87 The Fairway, Aldwick Bay Estate.

Ref AW/86/15/HH

“Single storey rear extension, reduce length of eastern garage with provision of new front skirt tiled roof to eastern garage, extend existing western lean-to roof & replace existing front black timbers”

sheet 2 of 3

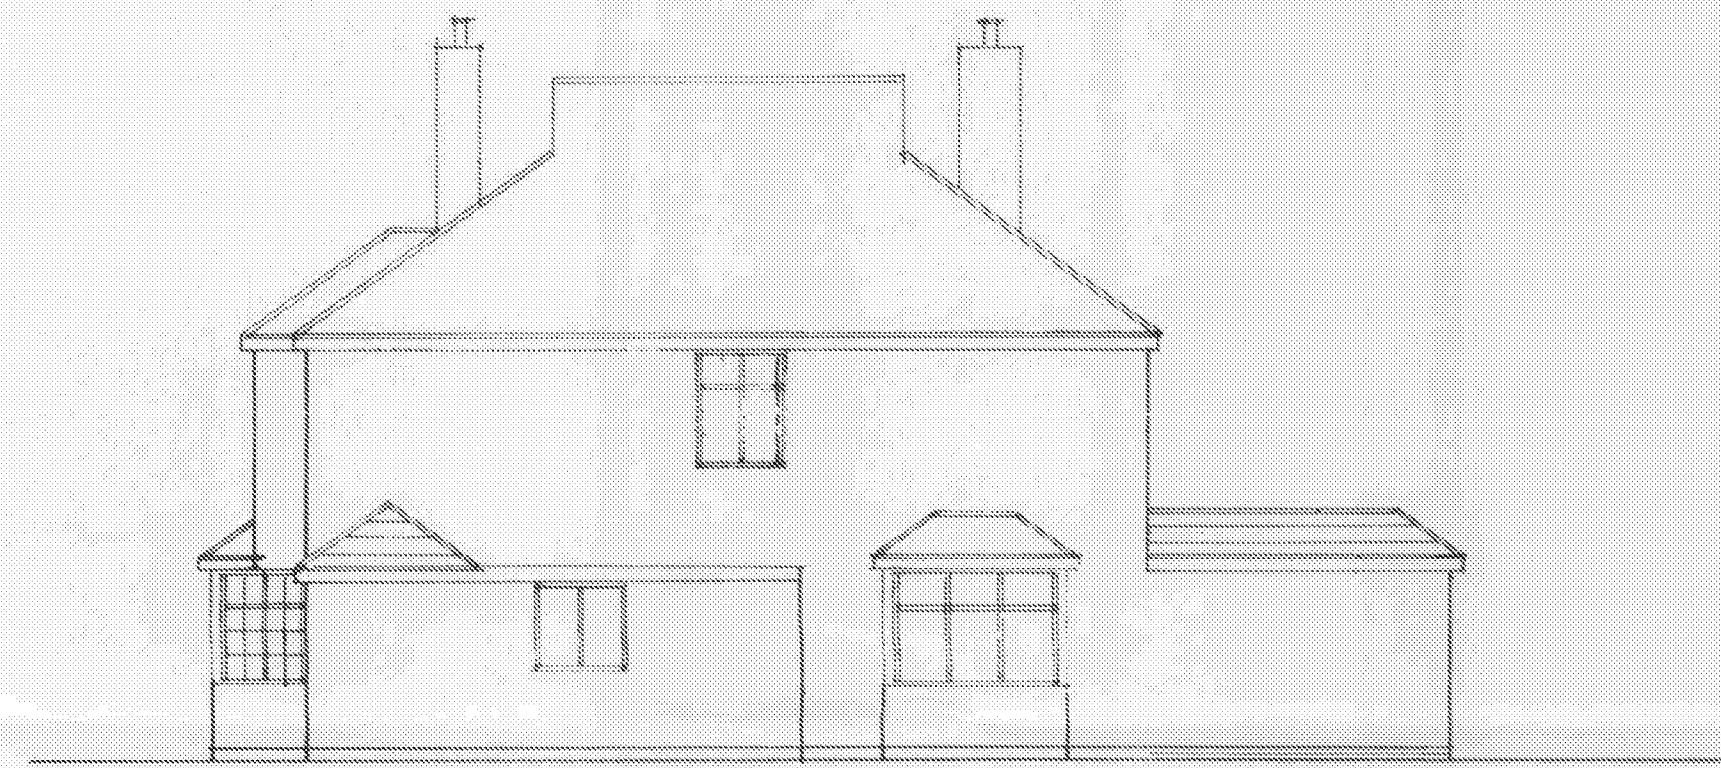
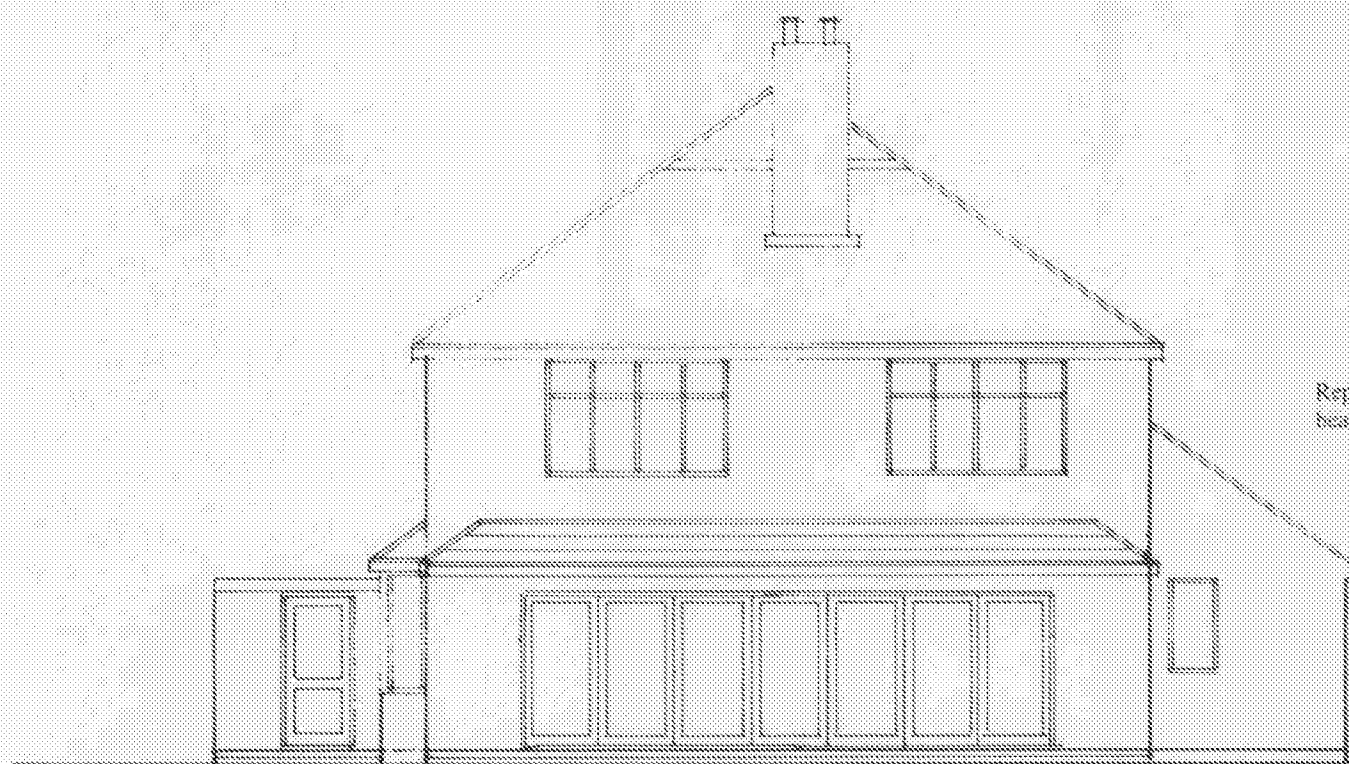
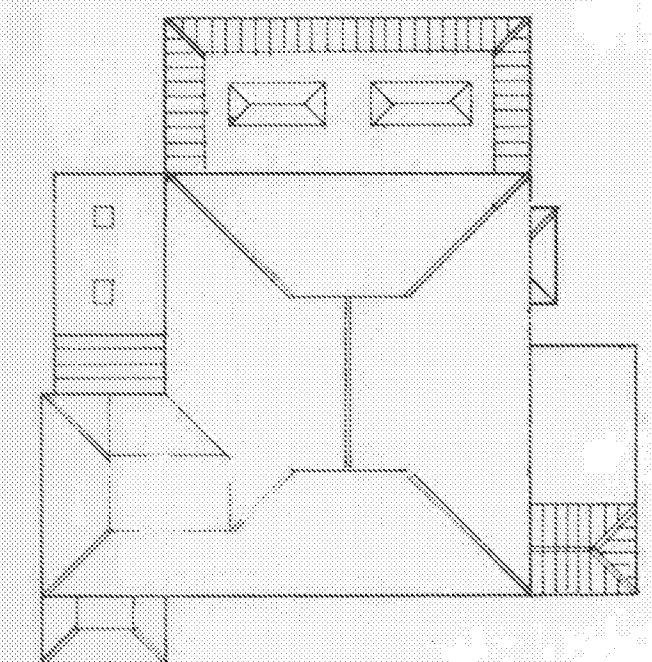
1. We have no objection to the size of the rear extension, provided the materials used and the detailing carefully match those of the original house. Although splitting the rear sliding folding doors into 2 or 3 openings rather than one very large, would be more appropriate as would increasing the height of the skirt roof.

2. Reducing the length of the eastern garage will be an improvement.
3. Addition of front skirt tiled roof will be an improvement, although the house is detached and viewed equally from the sides thus a fully tiled skirt or complete tiled roof would be a more holistic/appropriate approach.

4. Extending the western lean-to roof is an improvement.
5. Replacing existing stained black timbers with unstained/untreated English oak will be an improvement.
